**Consultation Response from KC,
Conservation & Design**
2022/91378 15, Lower Park, Park Lane, Berry Brow, Huddersfield, HD4 6TR
Listed Building Consent for erection of single and two storey rear extensions, rendering of existing stone to front and internal alterations
Date Responded: 17.06.2022
Responding Officer: Sebastian Pickles
Responding Ref:

Proposed Ground Floor Layout 1:100

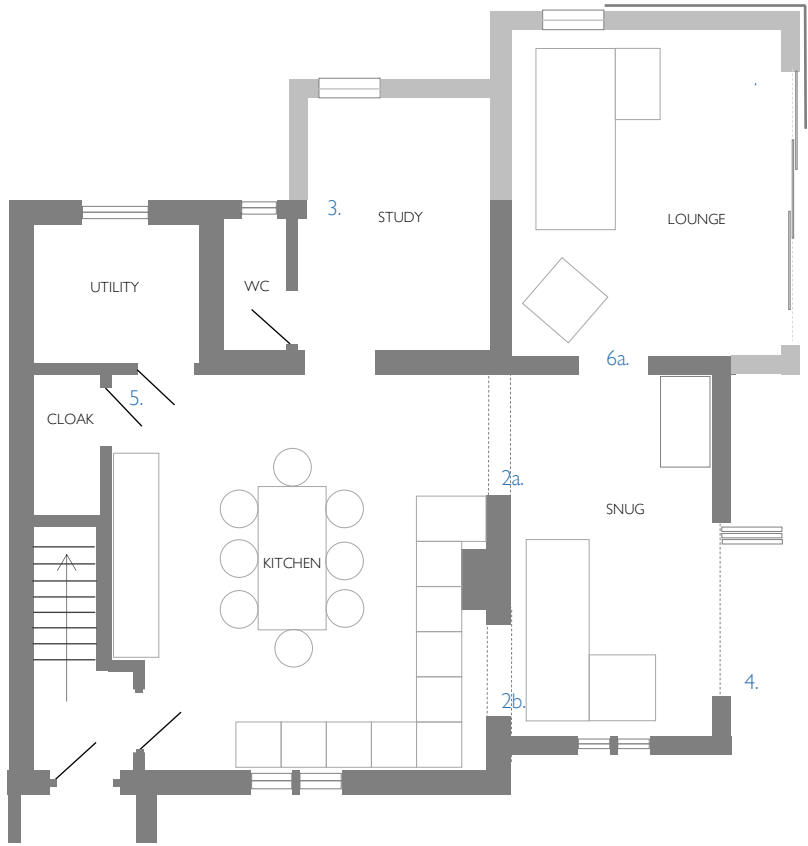
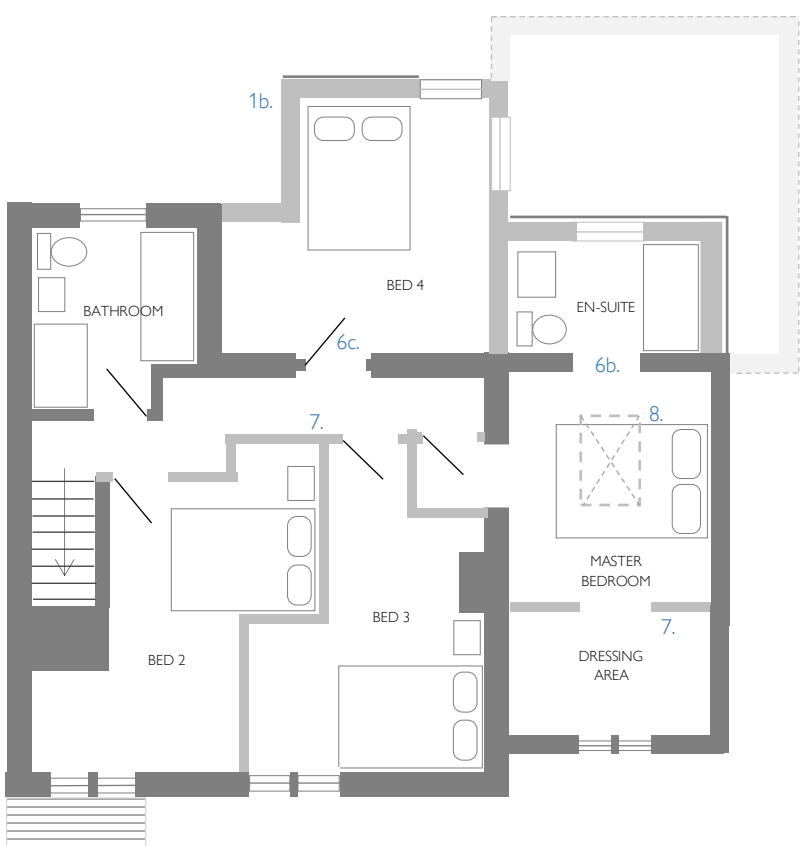
The proposals are for the addition of a single and two storey rear extension and internal alterations which include knocking through and loss of historic fabric.

Looking at the proposed internal alterations. As previously set out there is no assessment of the impact which the proposed works would have to the significance of the building and therefore there can be no assessment made at this time until a further detail assessment has been made.

Focusing on the proposed internal works. As set out there is currently no assessment for the impact of the works and how they will impact the significance and character of the Listed Building. To reiterate the Listing covers the whole building. At this stage a full assessment of the internal works can not be completed. If further detail is provided then this can be undertaken. We are however currently not satisfied with the submitted detail and assessment.

Proposed Rear Elevation 1:100

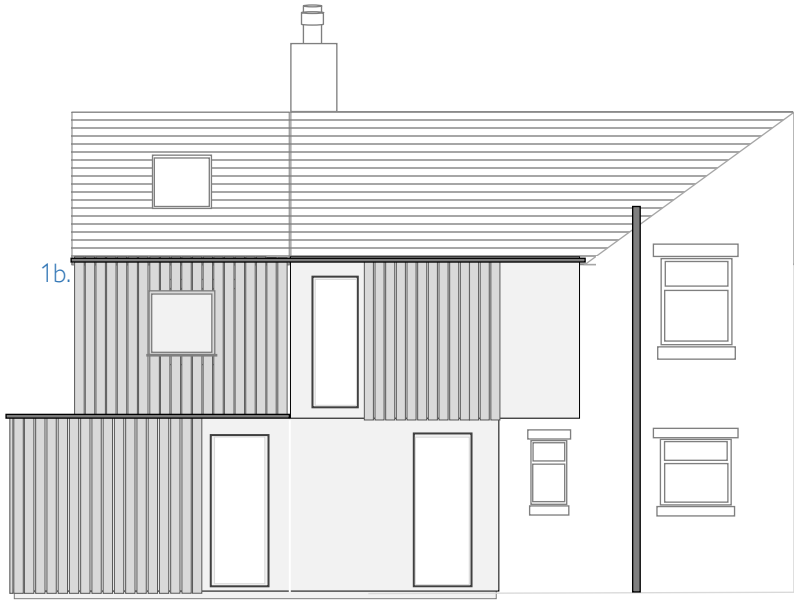
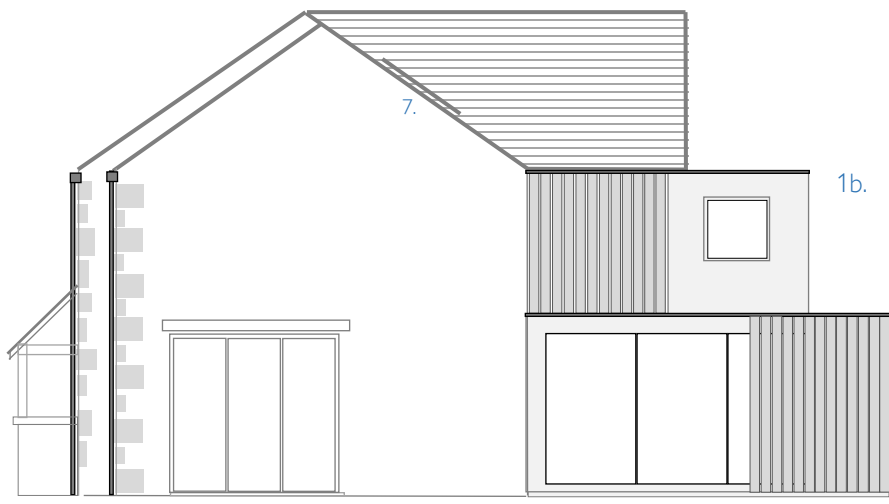
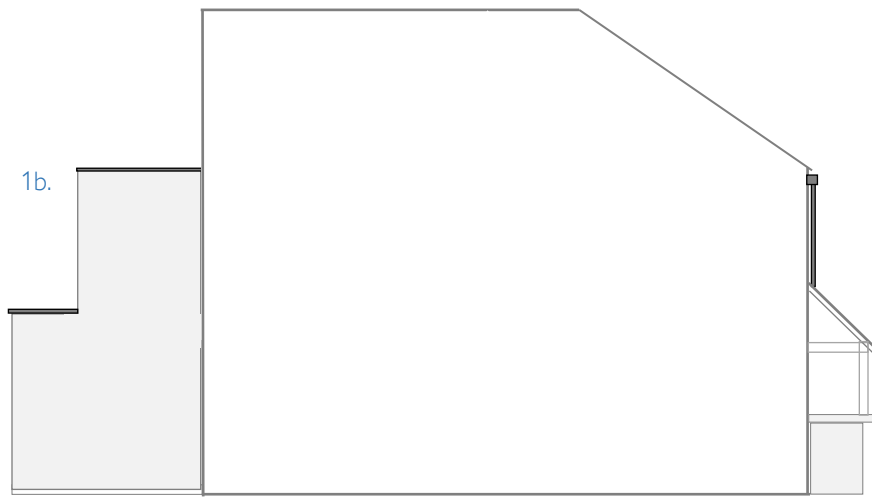
The proposed extensions are in a highly contemporary design. It is recognised that sometimes the use of contemporary design can be considered to create a contrast between the historic and new additions. This is however very much dependent on the level of intervention and whether it would enhance the character of the historic form. In this instance we would not consider it to be the case. The proposed would see additions which are entirely alien and conflicting with the historic form and character of the building. We accept that part of the proposed impact the more recent 2006 side extension, however the proposed are not considering the overall impact to the building.

There is also no consideration of the impact to the setting and views onto the building. While being located to the rear, the proposed extension would be experienced in the immediate context of the site. There are also views onto the site when looking from the north off Park Lane and there are long views off Cold Hill Lane. The proposed extension would be entirely incongruous, and they have a feel of something which may be found within a more urban context, apposed to the rural, countryside setting of the site.

As currently presented, Conservation would raise an objection to the proposed extension to the rear of the property. The concerns stem from the lack of understanding and assessment of the building. We do not consider the submitted Heritage Statement to be sufficient to meet the requirements of Policy 194 of the NPPF. The proposed extensions would have a harmful impact on the Listed Building. The proposals would not be supported by Policy LP24 of or LP35 of the Local Plan. The design is entirely alien to the building and would have a harmful impact to the building. There is no sufficiently justified reason for the proposed extensions. We are also not in agreement that the proposals are reversible. The proposed extension would not accord with Policy 66 of the Planning (Listed Building and Conservation Areas) Act.
